CITY OF ALBUQUERQUE

November 2, 2023

RE: Roses SW Papers
TR D-6 PLAT OF TRACTS D-1 THRU D-7 MESA DEL SOL
INNOVATIONPARK II
Grading and Drainage Plan
Engineer's Stamp Date: 10/17/2023
Hydrology File: Q16DA5000C

Based upon the information provided in your submittal received 10/18/2023, the Grading & Drainage Plan **is not** approved for action by the DFT on Site Plan for Building Permit. The following comments need to be addressed for approval of the above referenced project:

Easement Notes

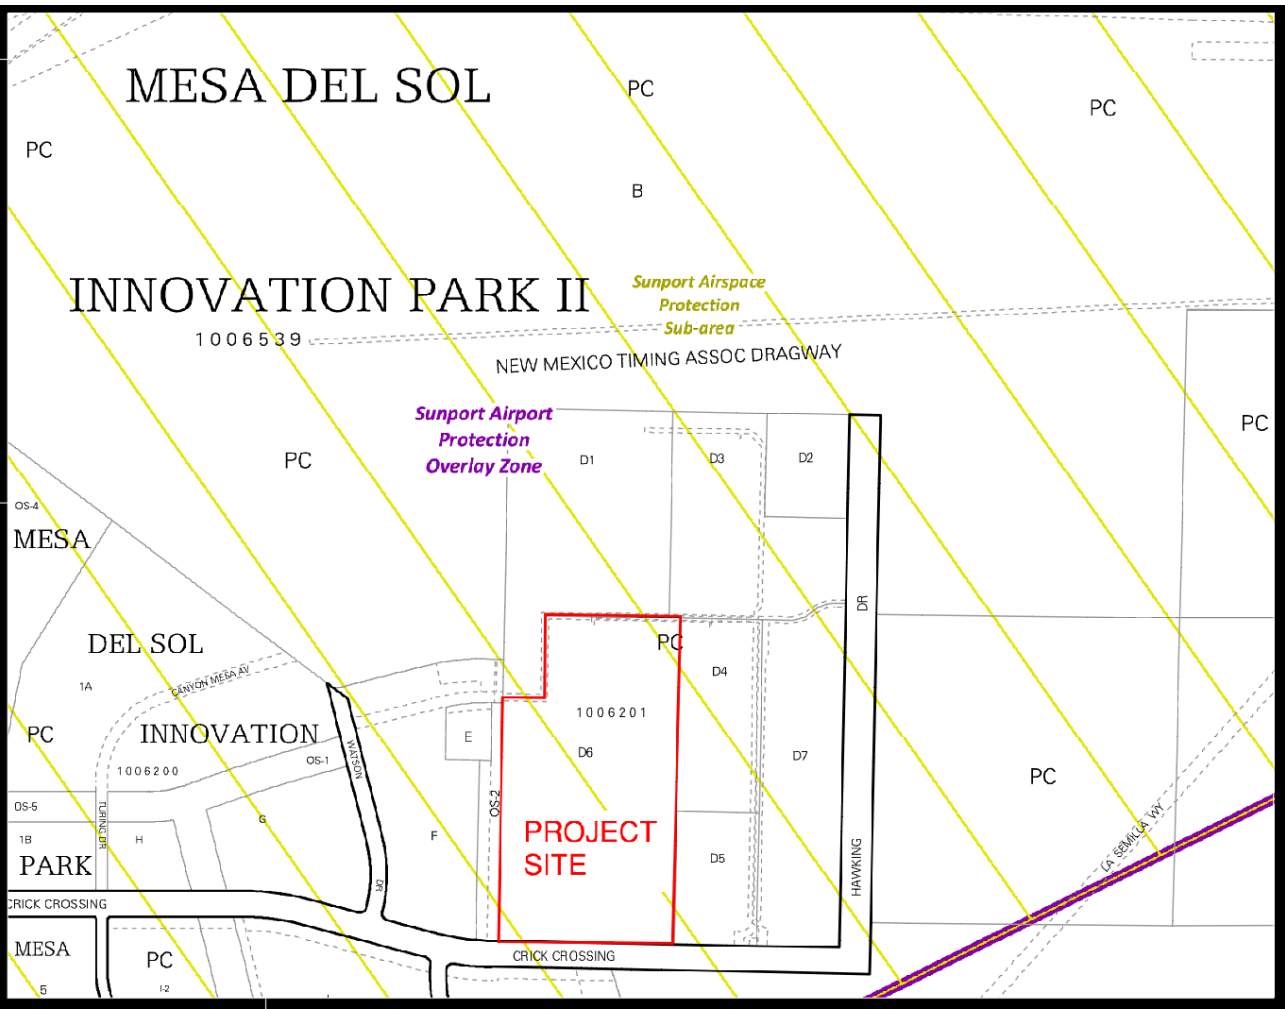
1. Please provide legend and benchmark information (location, description and elevation) for the survey contour information provided. Create drainage easements for the retention pond and future pond.
2. Sheet CD-0: what do the circled numbers mean in "Easement Notes".
3. Sheet CD-2: Add spillway with erosion protection plan to the retention pond.
4. Provide details for the SD pipes, e.g. material, size, length, drop inlets and manhole locations and rip-rap size and dimension information. Add rip-rap symbol to the legend.
5. Sheet CD-3, notes IV & V: Use the 100-year 10-day storm event for hydrologic calculations per the City of Albuquerque DPM section 6-11(I)2.

A1 DRAINAGE PLAN - OVERALL

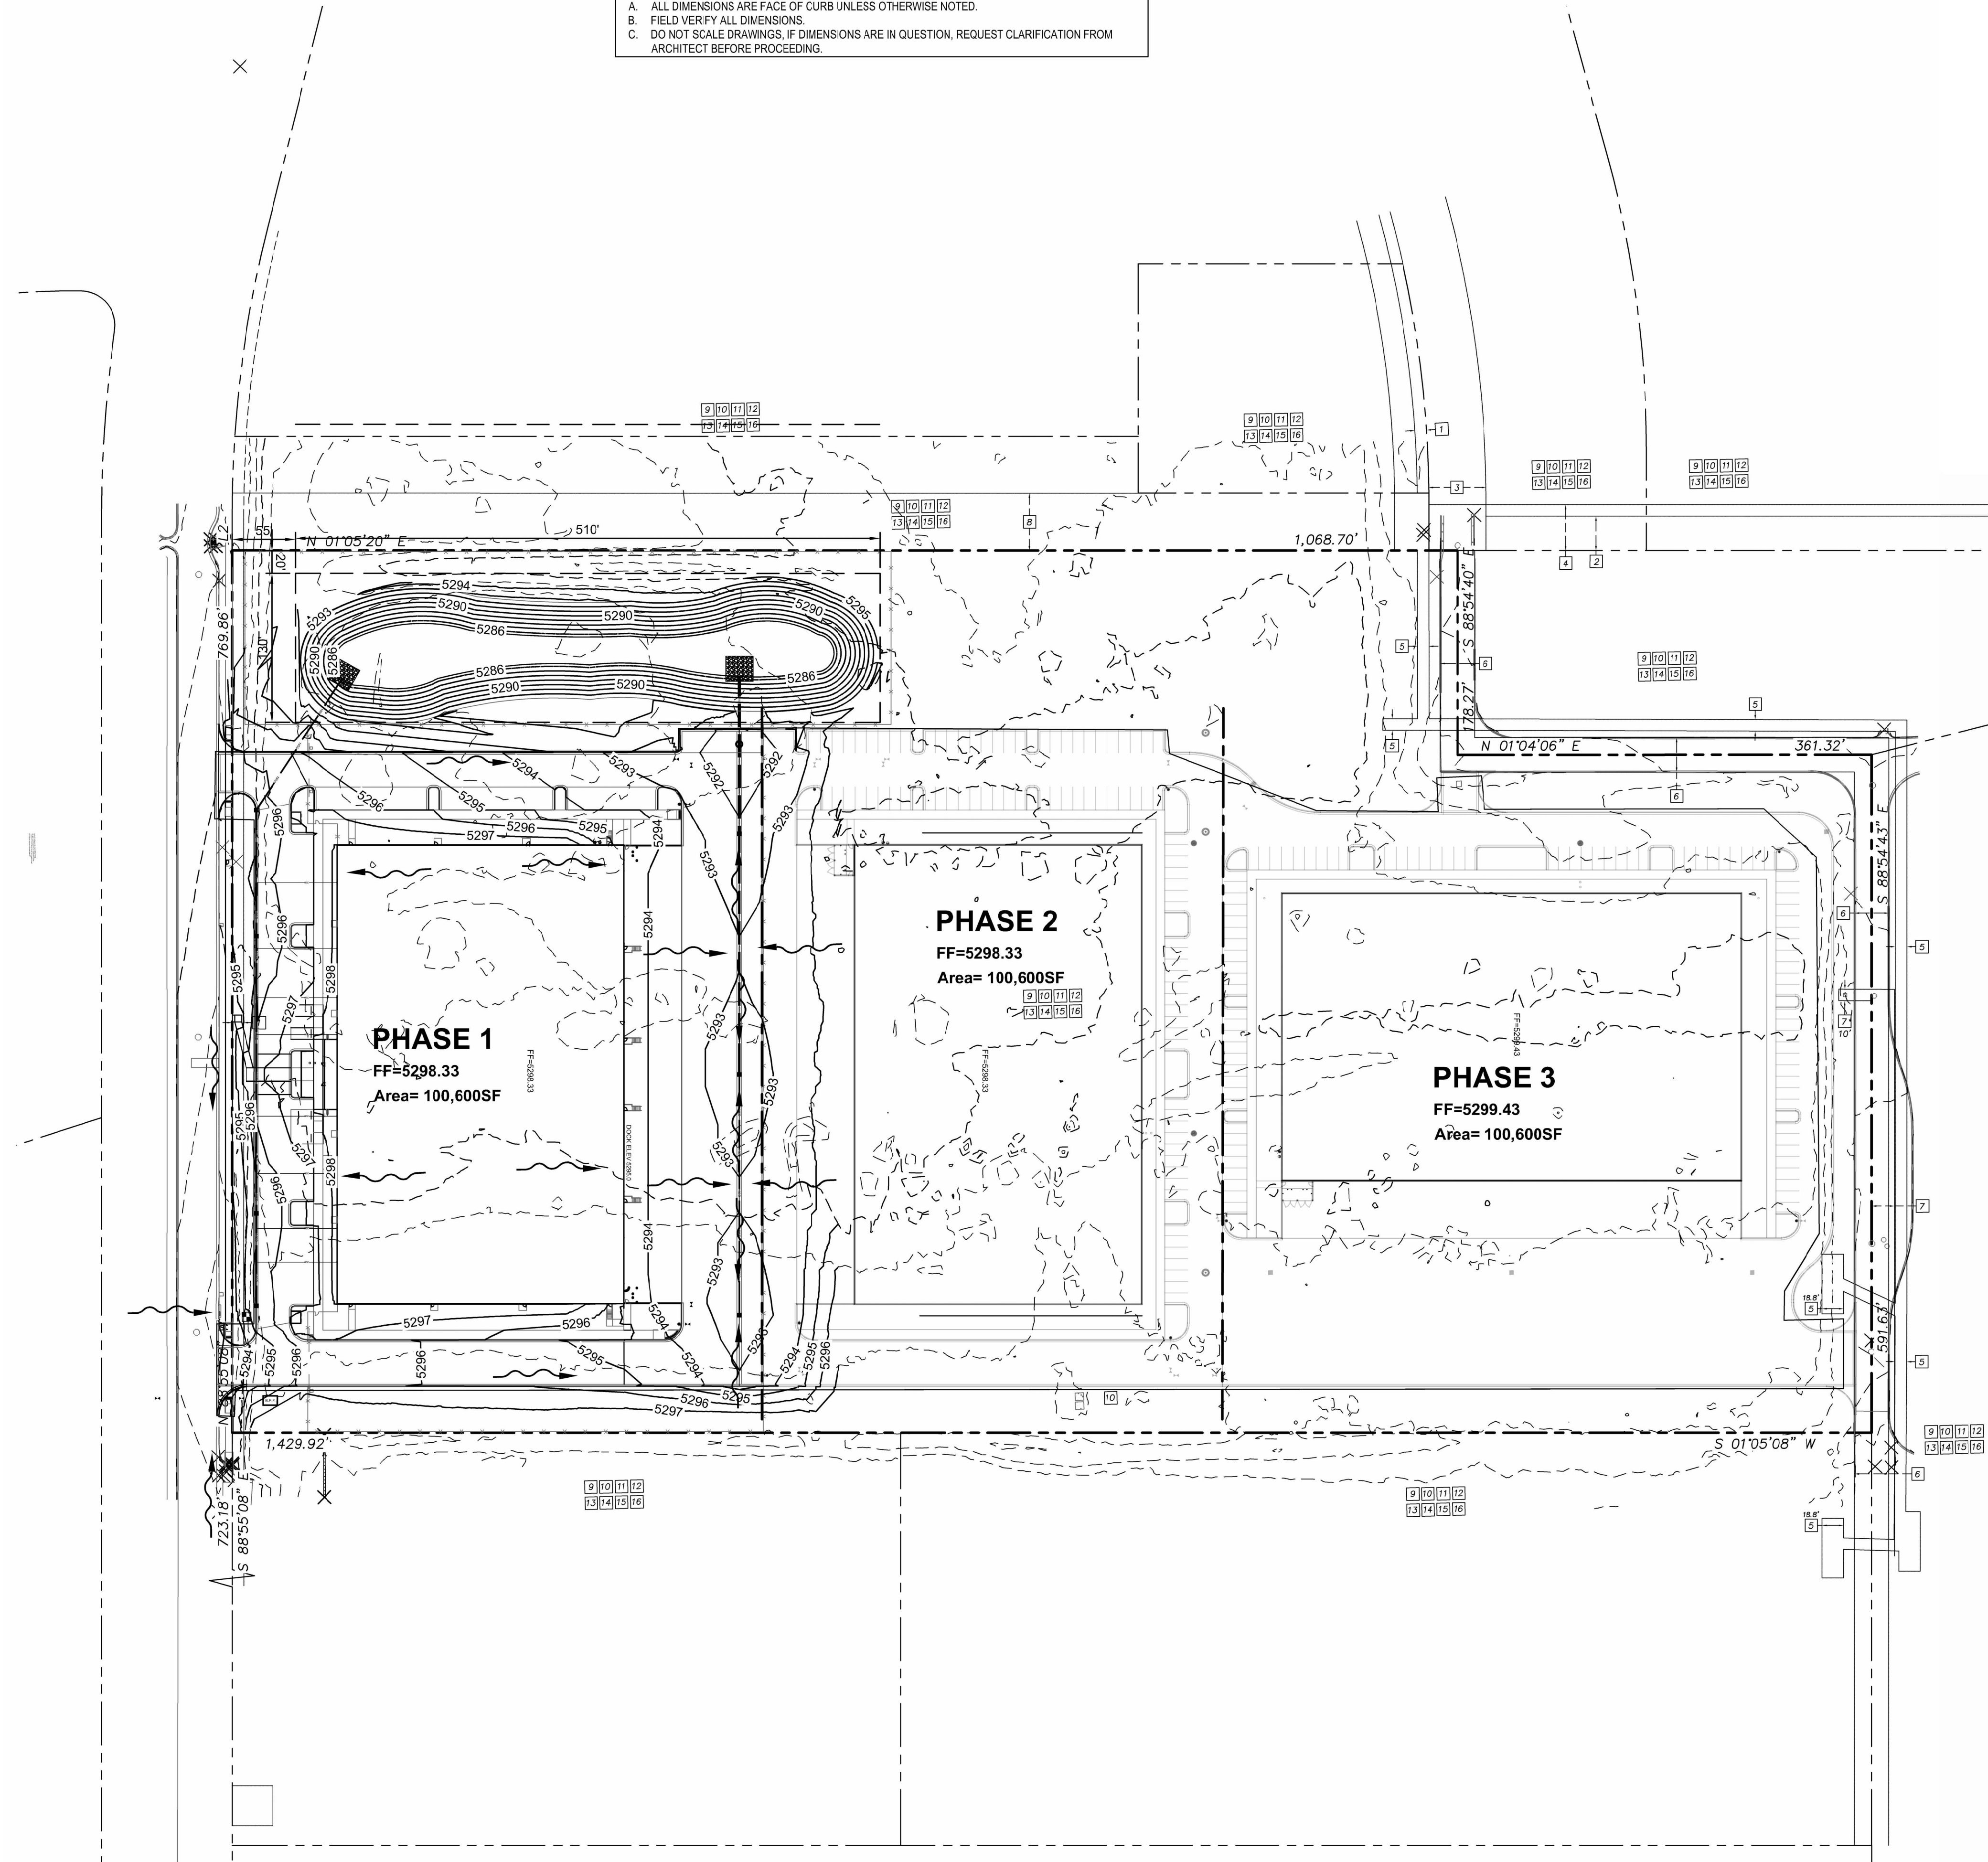
6. Note VI: Change the new building size from 100,000 SF to 100,600 SF.
